Arun District Council
Arun Civic Centre
Maltravers Road
Littlehampton
West Sussex BN17 5LF
Planning & Building Control General Enquiries
Tel: (01903) 737756 Fax: (01903) 730442
Dx: 57406 Littlehampton
Minicom: 01903 732765
e-mail: planning@arun.gov.uk
website: www.arun.gov.uk/planning

Application No: FP/84/22/PL
Site Address: 7 Ambleside Close Felpham PO22 8NG
Description of works: Erection of 1 No three-bed detached dwelling (resubmission of FP/86/21/PL). This site is in CIL Zone 4 and is CIL Liable as a new dwelling.

Thank you for your internet representation made on 23rd June 2022 which has been recorded as an objection with the comments as follows:

PROPOSED SITE PLAN
SCALE: 1:100 @ A1

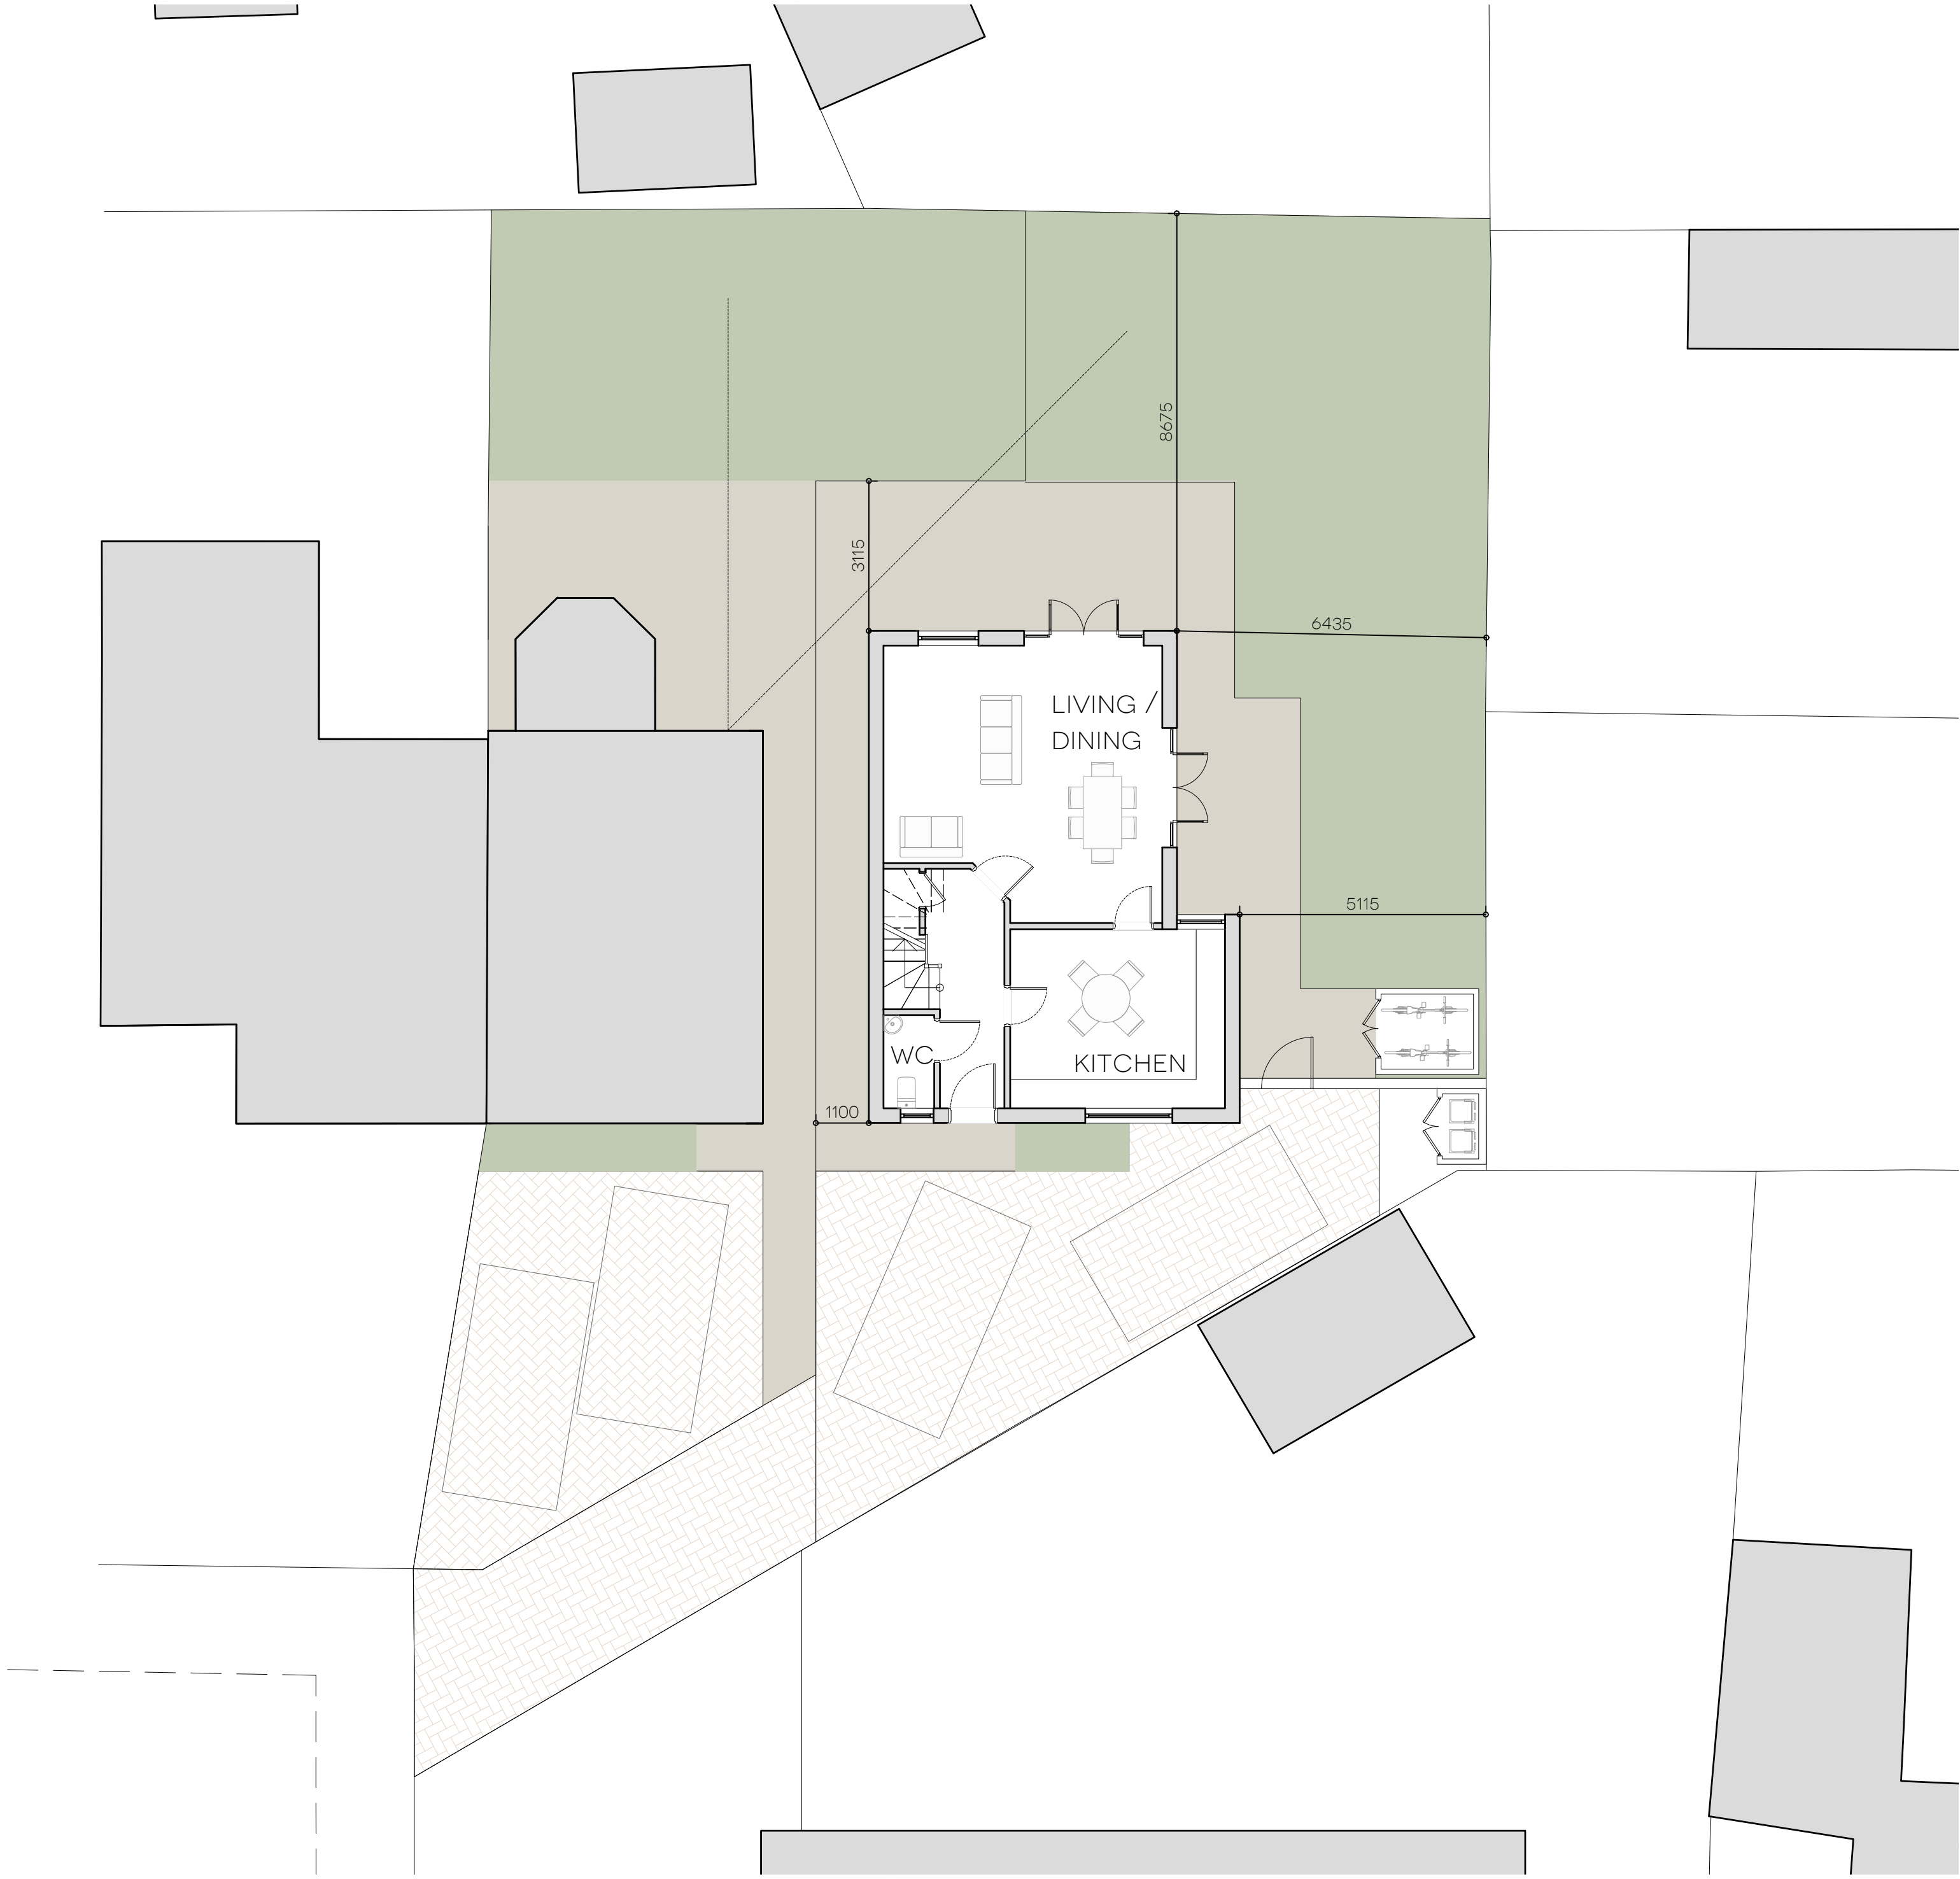
I object to the proposed plans as construction of another property within the garden of no7 will cause overcrowding within a small cul de sac. The property does not look in keeping with the rest of the properties and will leave the original 3 bedded semi detached property with a very small back garden/plot which is not in keeping with a 3 bedded family home.

Access to both of the properties would be by a single shared driveway which is very limited in space to get to parking spaces in front of the properties and manoeuvres to get out of due to the borders of the surrounding properties. Also there could be issues when leaving rubbish bins out for waste collections on the end of a single shared driveway and very close to neighbouring properties.
